19th September 2017

Ref: Application No FG/135/17/PL – 1 Beehive Lane, Ferring

DRAWING TITLE
Apartment 9
Block and Location Plan

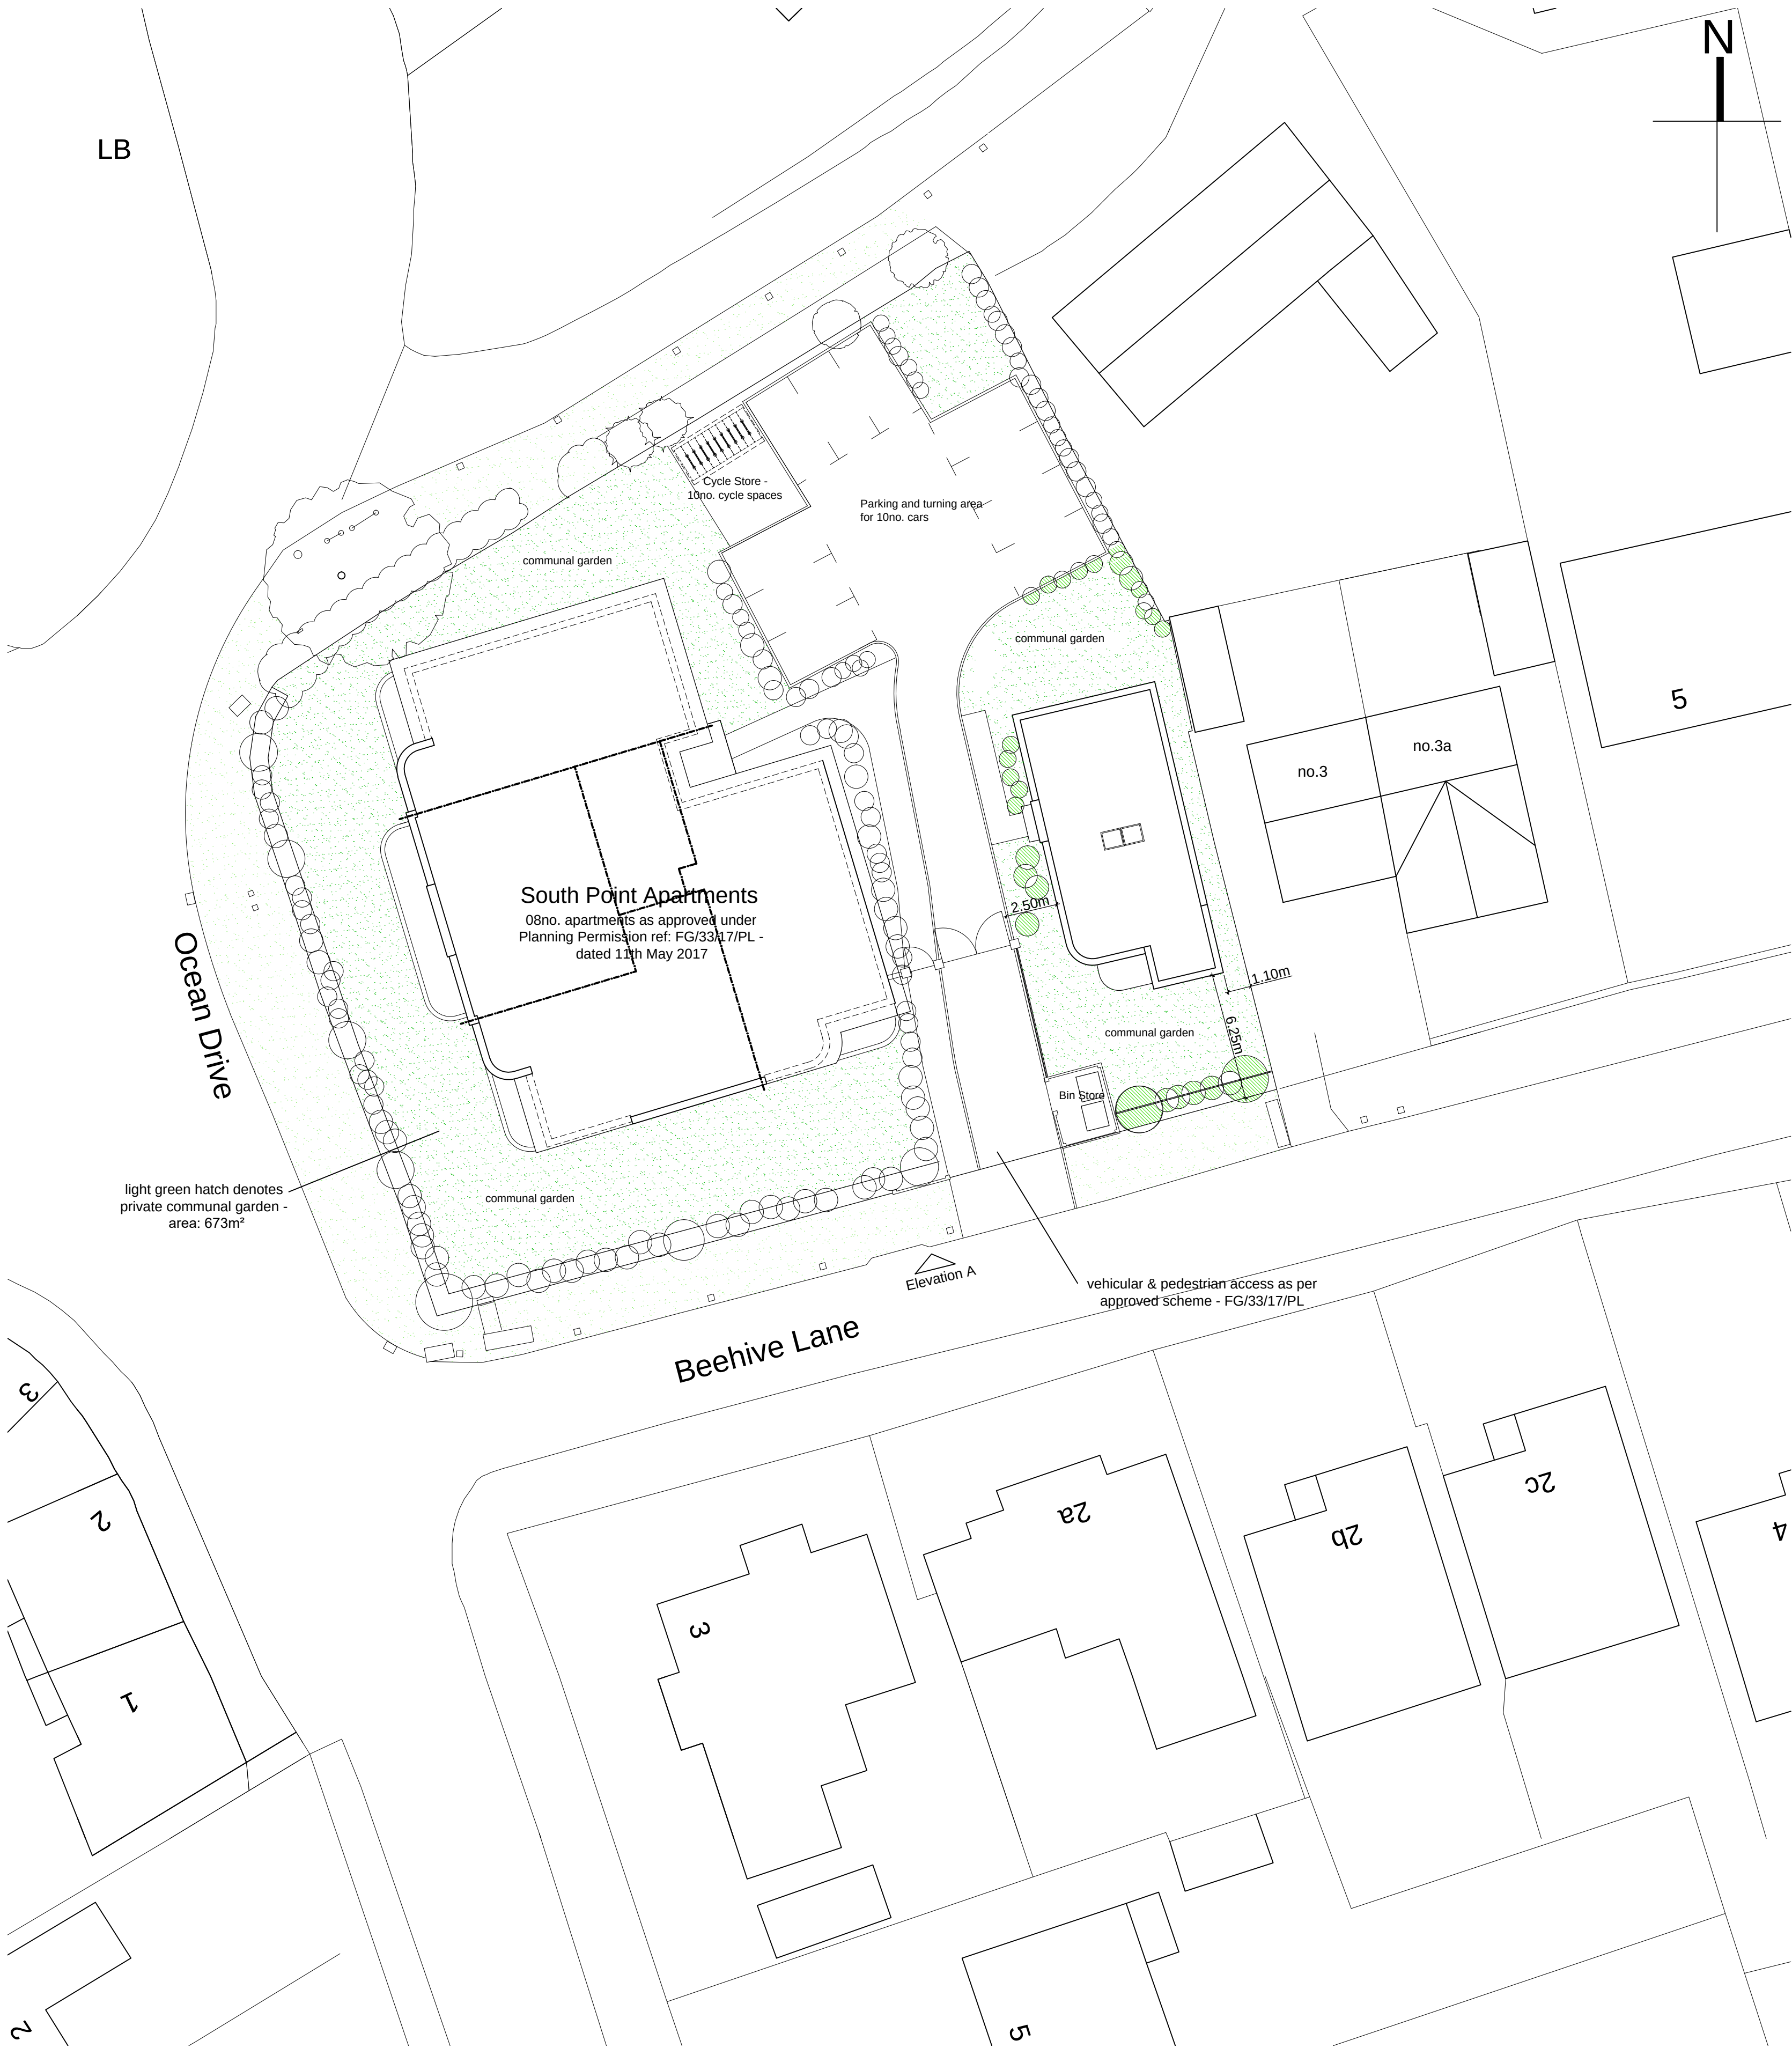
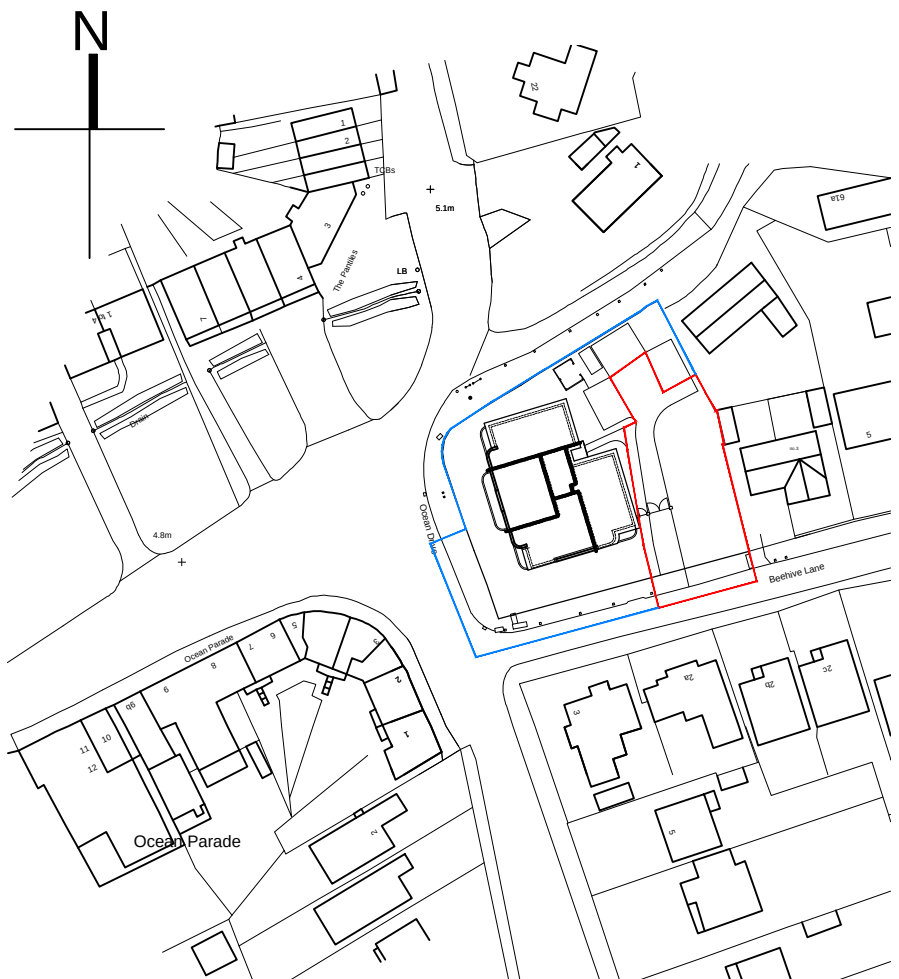
In my opinion (along with many other local residents) the proposed car parking provision of 10 spaces within the approved scheme was insufficient for 8 two bedroom flats. The new application is not providing for any additional parking on site, which means nine two bedroom dwellings have to share 10 spaces, all of which will apparently be unallocated if this can be believed (see Planning Statement para 5.6). It is likely that some of the flats will have two cars, so it will be a first come basis for the use of the spaces with the unlucky residents and visitors parking presumably in Beehive Lane or in front of the shops and flats opposite. This will inevitably be extremely stressful for all concerned. I imagine that the spaces have to be unallocated or the car parking provision will not meet current standards, so I presume the LPA must be responsible for monitoring this. I am afraid I cannot envisage this happening. I actually find it hard to believe the developer will not sell the flats without an allocated space each which would mean the parking provision is insufficient, which of course it is.

- (1) It will be an overdevelopment of the site
- (2) The new dwelling will be out of character with the adjoining properties in Beehive Lane
- (3) The new dwelling will have a serious impact on the amenity of the immediately adjacent dwelling contrary to the provisions of Gen 7 (ii and iv) of the Arun District Plan
- (4) The car parking provision is inadequate for nine two bedroom dwellings
- (5) The reduced amenity and garden space for the approved eight flats will be inadequate
